CITY OF ALBUQUERQUE

**RE: Albuquerque Biopark Zoo - Carousel Area
COA Zoo 903 10th St SW
Request Permanent C. O. - Accepted
Engineers Stamp Date 4/10/15 (K13D034E)
Certification date: 3-18-16**

**RE: Biopark- Carousel Area
COA Zoo 903 10th St SW
Grading and Drainage Plan
Engineers Stamp Date 4/10/15 Revision 5/29/15 (K13D034E)**

RE: **Biopark- Carousel Area**
COA Zoo
Grading and Drainage Plan
Engineers Stamp Date 4/10/15 (K13D034E)

SHEET NUMBER
C2.1

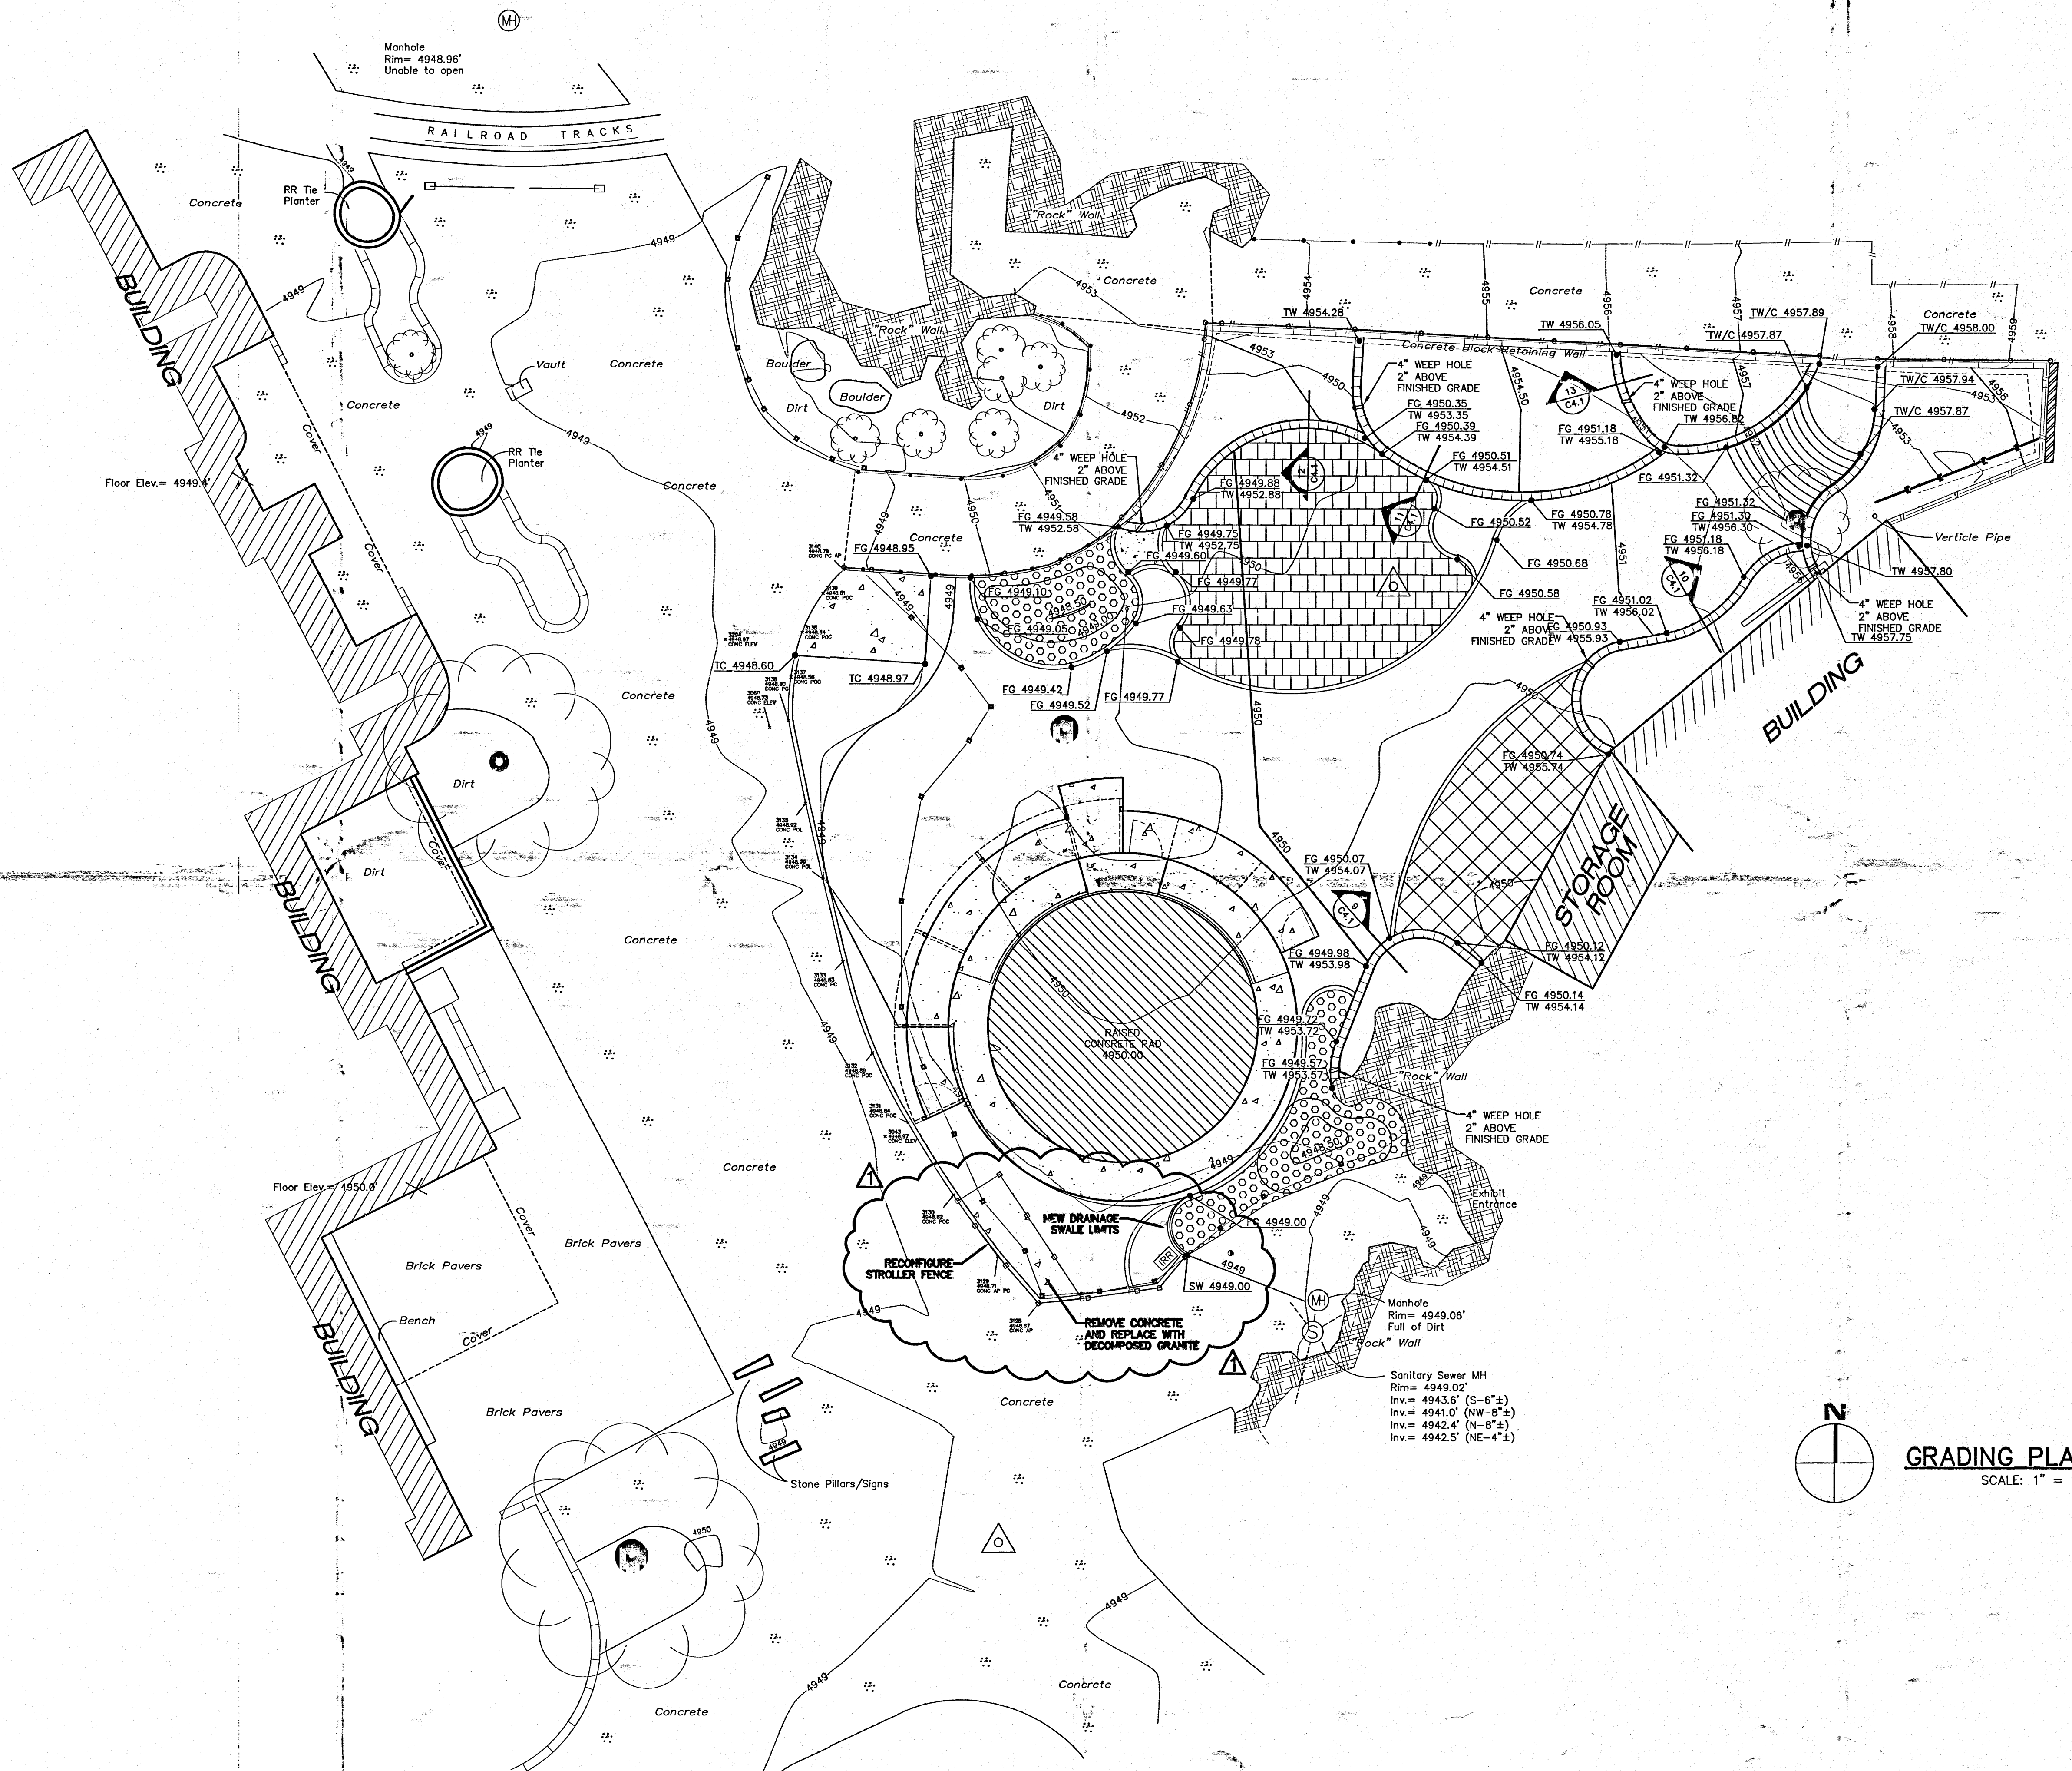
Based upon the information provided in your submittal received 5/20/2015, the above referenced Grading and Drainage Plan cannot be approved for Grading Permit or Building Permit until the following comments are addressed.

- Provide a site plan and FIRMette of this location.
- Provide a table of calculations for land treatments, percentages, existing and proposed flows.
- Provide a legal description of this site.
- Show or mention the location of the bench mark.
- Provide how flows will leave this area.
